City of Albuquerque

**RE: REVISED GRADING AND DRAINAGE PLAN FOR NEAL MEISNER,
LOTS 7 & 8, RICHFIELD PARK, (C17/D2A15), ENGINEER'S STAMP
DATED 10/9/95.**

**RE: GRADING AND DRAINAGE PLAN FOR NEAL MEISNER, LOT 7 & 8,
RICHFIELD PARK, (C17/D2A15), ENGINEER'S STAMP DATED
4/27/95.**

RE: GRADING AND DRAINAGE PLAN FOR NEAL MEISNER, LOT 7 & 8,
RICHFIELD PARK, (C17/D2A15), ENGINEER'S STAMP DATED 3/30/95.

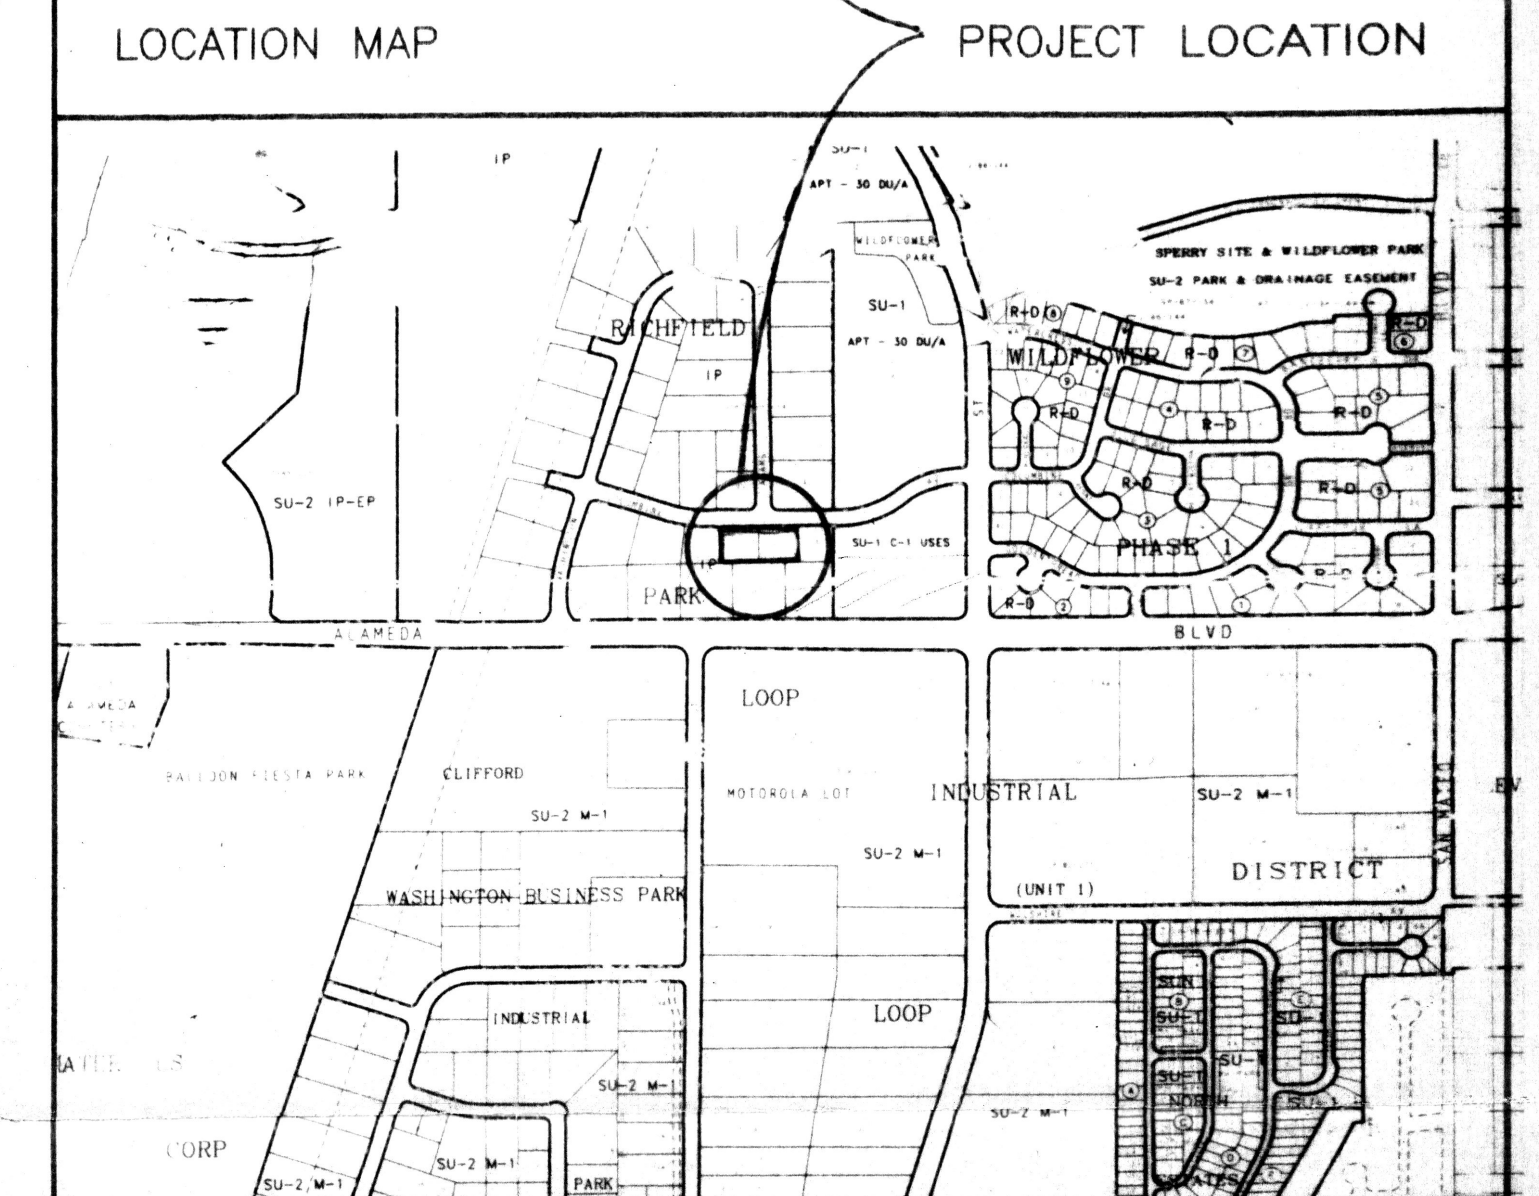
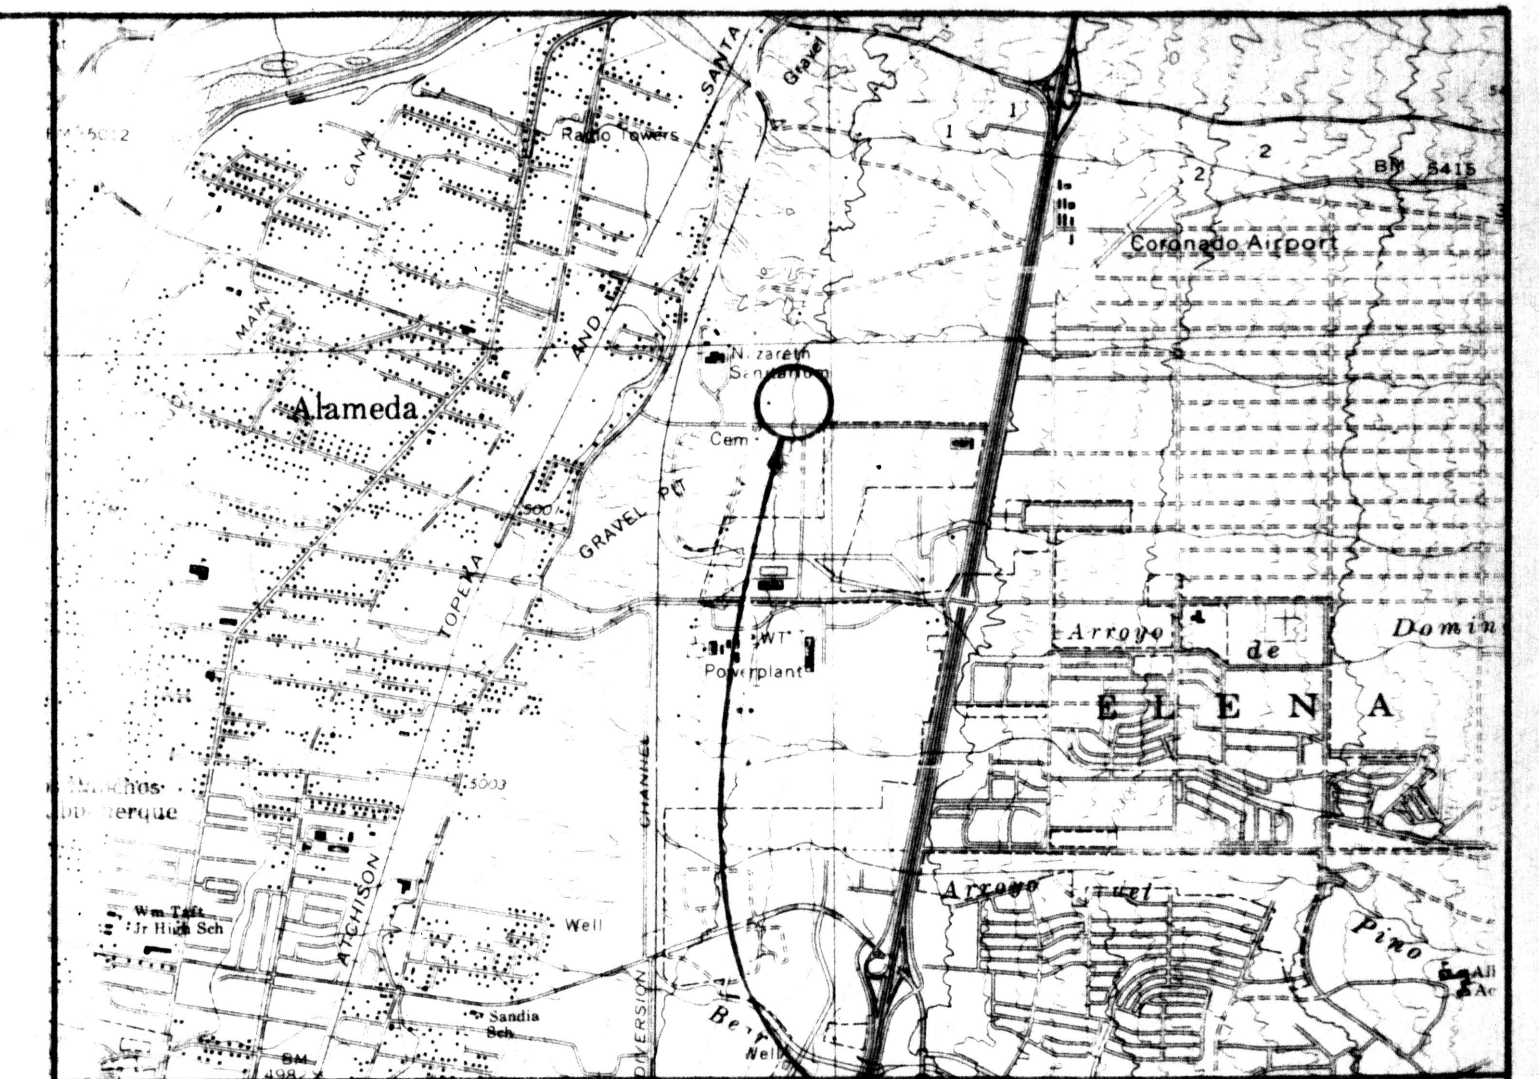
1. As identified on FIRM panel 9, a portion of this property is within a FEMA floodplain, specifically within zone AO, depth 1. The City flood hazard ordinance requires that the finish floor elevation be a minimum of one foot above the base flood elevation (bfe). Adjacent to this site, the flowline is approximately at elevation 104.62, therefore the bfe would be at elevation 105.62 (at 1' depth), and the finish floor should be at 106.62. Although improvements have been constructed in the area, it is recommended that the finish floor elevation be raised.
2. The plan must address off-site flows. It appears that off-site flows enter the site from the east.
